Our Ref: AB/46/18/HH

**Town & Country Planning Act 1990 (as amended)
Town & country Planning (Development Management Procedure) (England) Order 2015
Application for Planning Permission for Works or Extension to a Dwelling**

Development Single storey front, side & rear ground floor extension & loft conversion with associated drainage works (resubmission following AB/70/17/HH).

Location 3A Fitzalan Road Arundel

BLOCK PLAN - SCALE 1:500

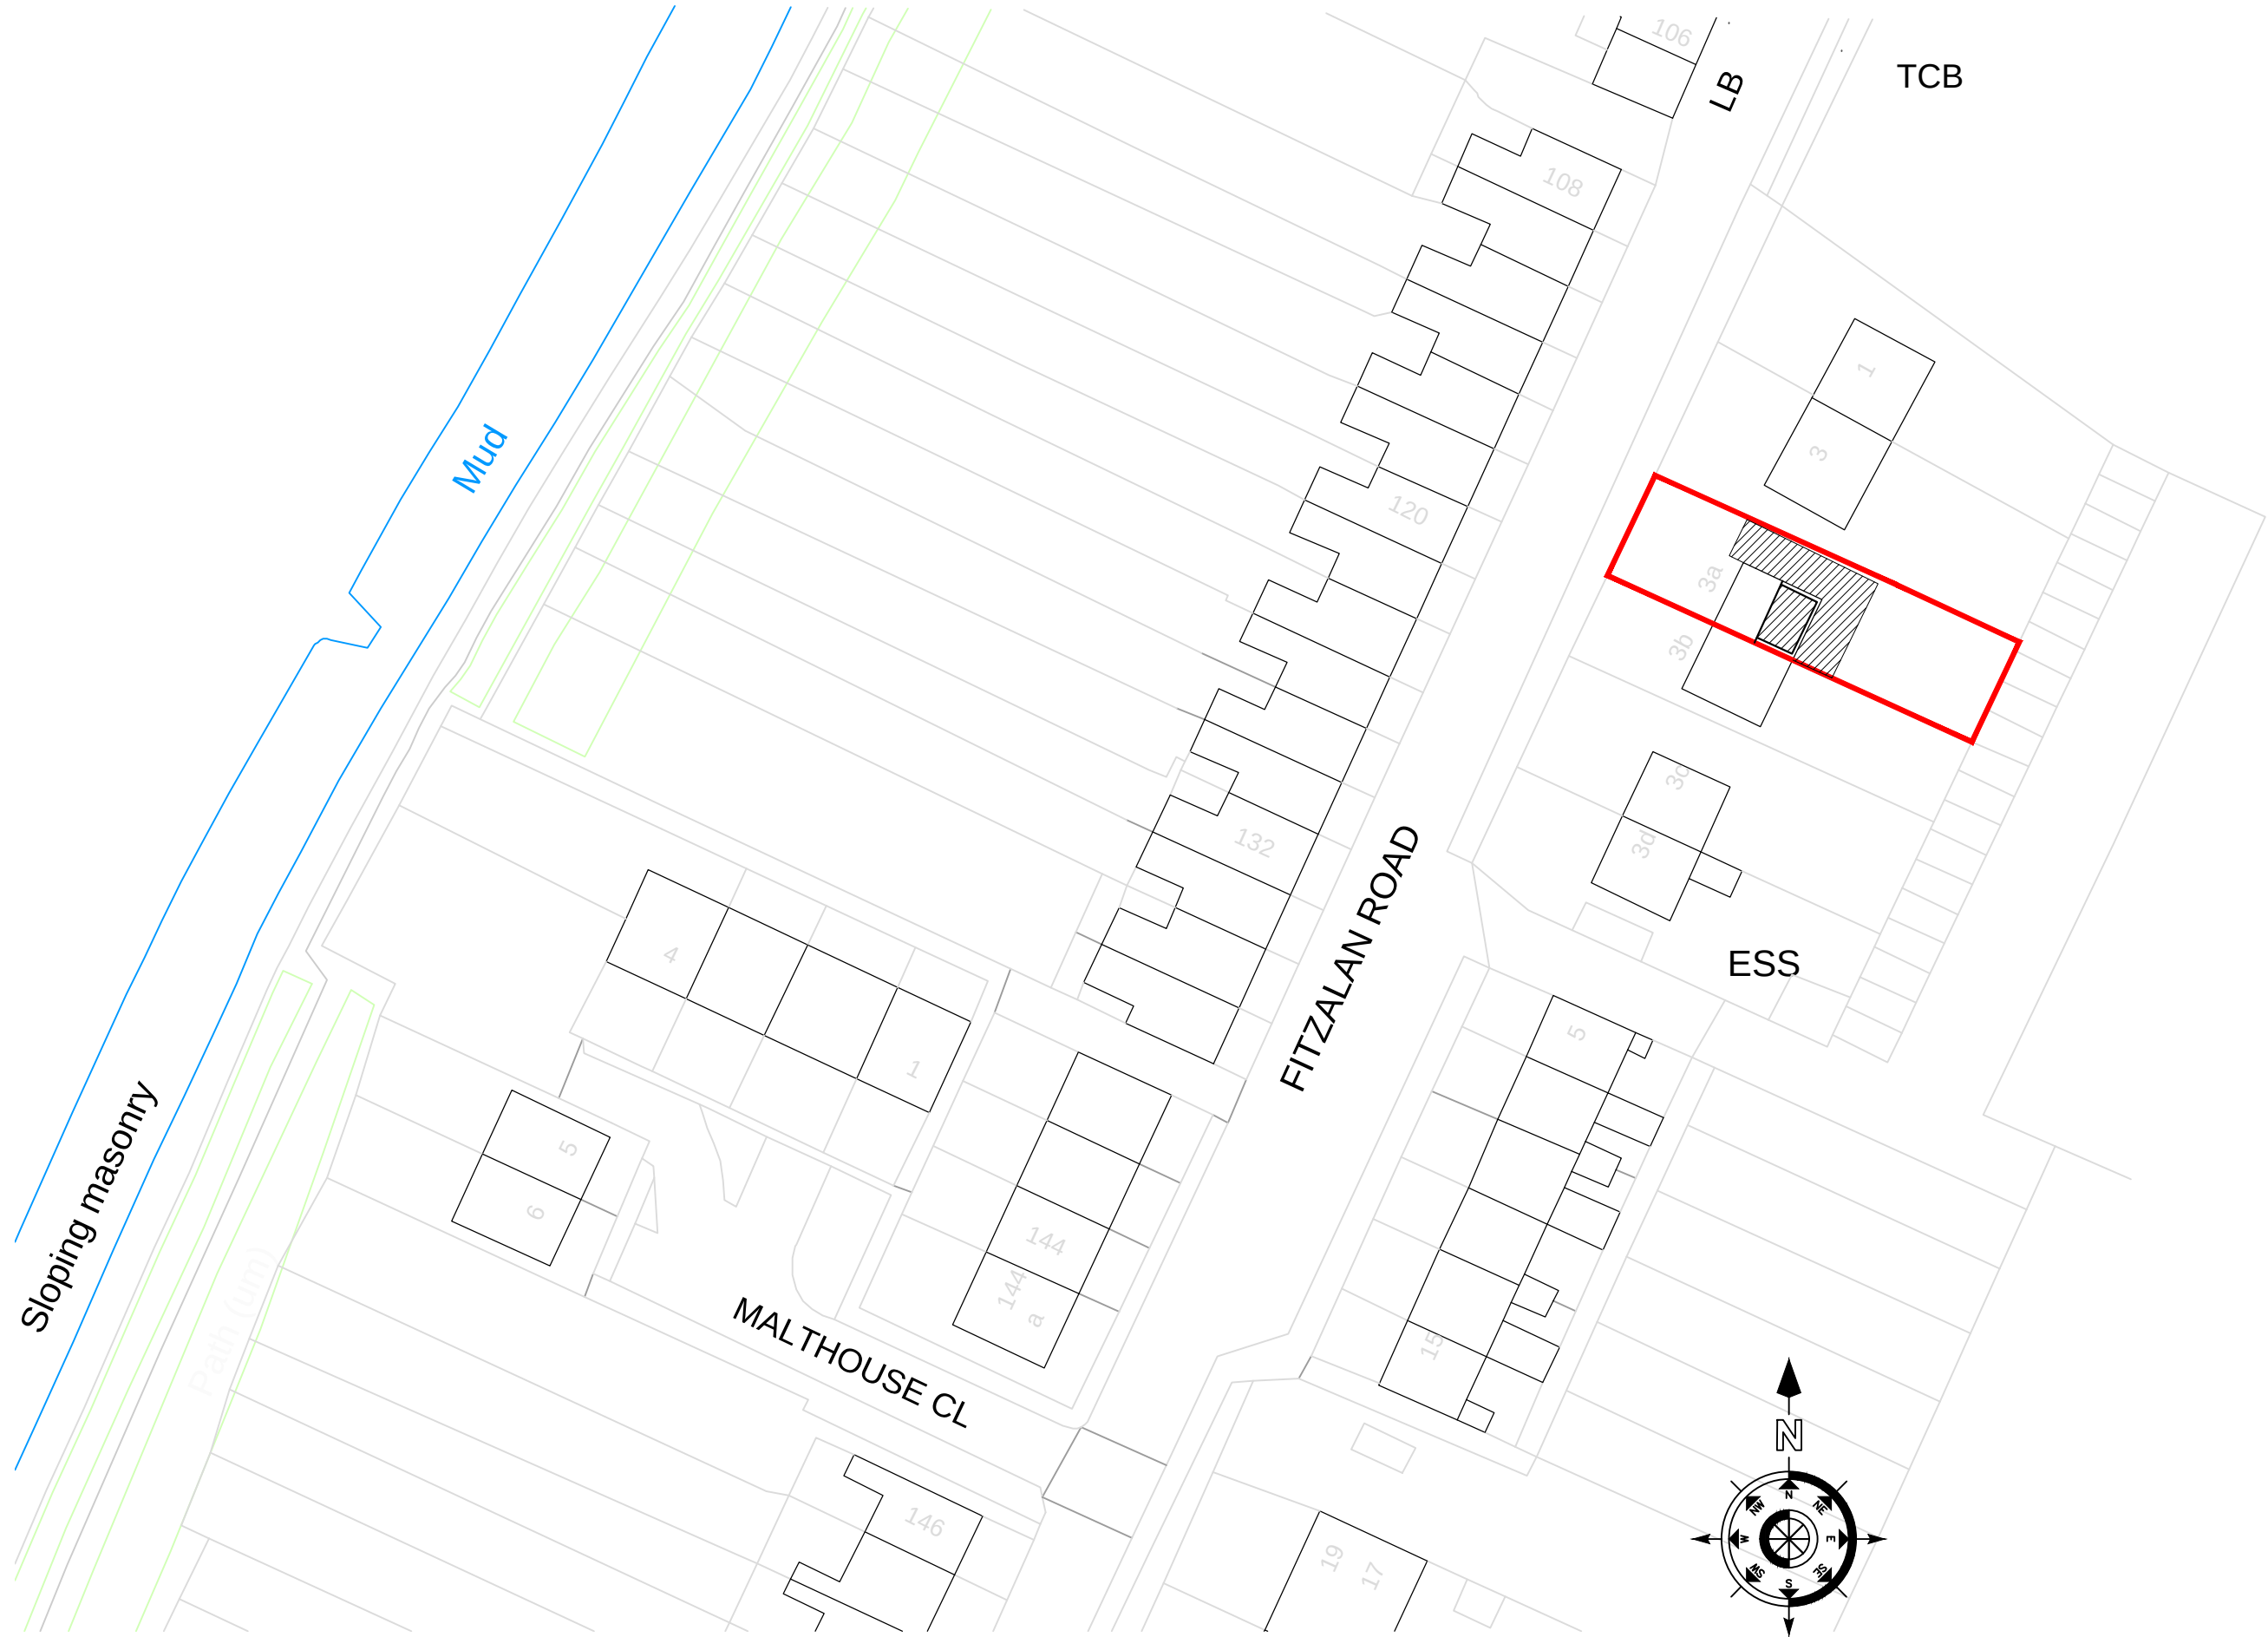
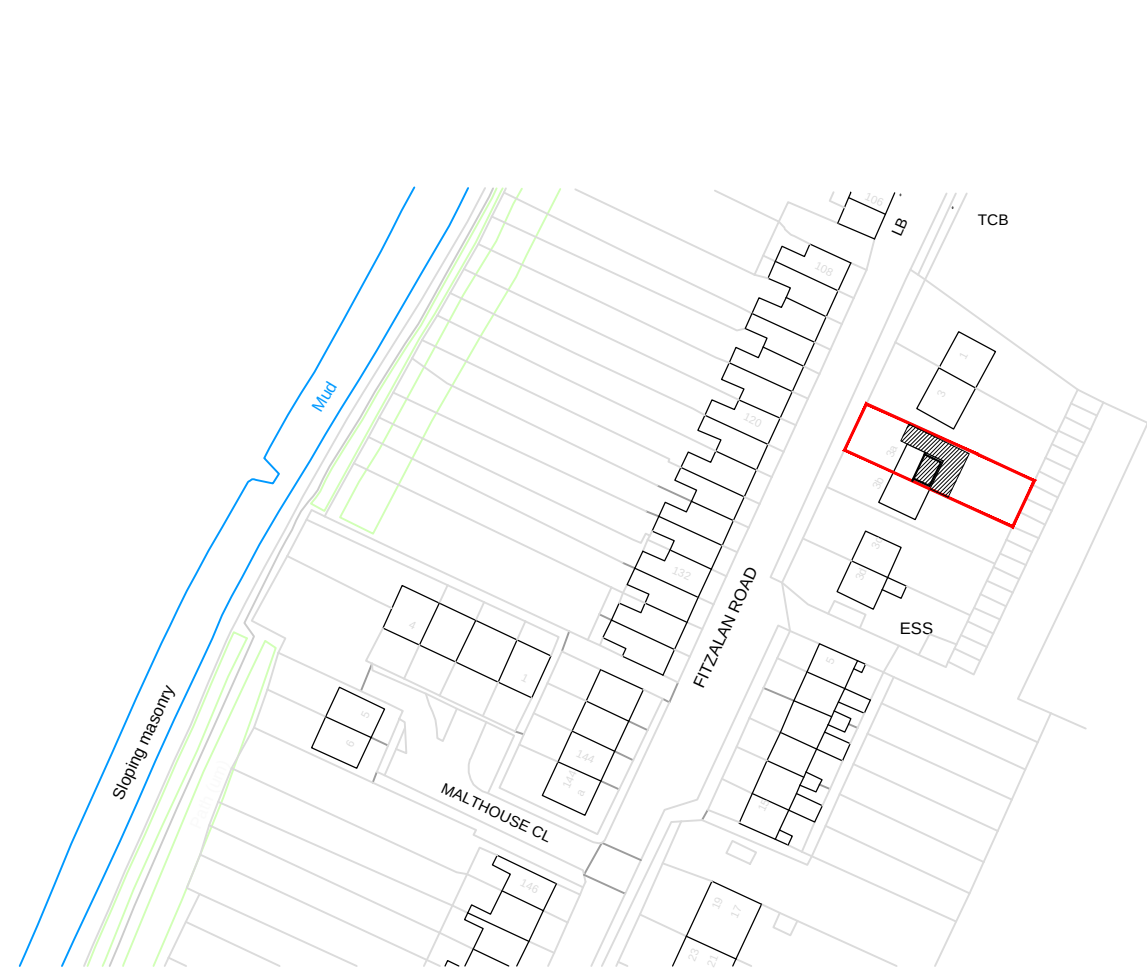
Block Plan Block

Please submit 1 electronic or 3 paper copies of a block/site plan at a scale of 1:500 or 1:200. Further details of what must be included on the plan can be found in the National Validation Requirements. Please provide measurements from the proposals to the site boundaries.
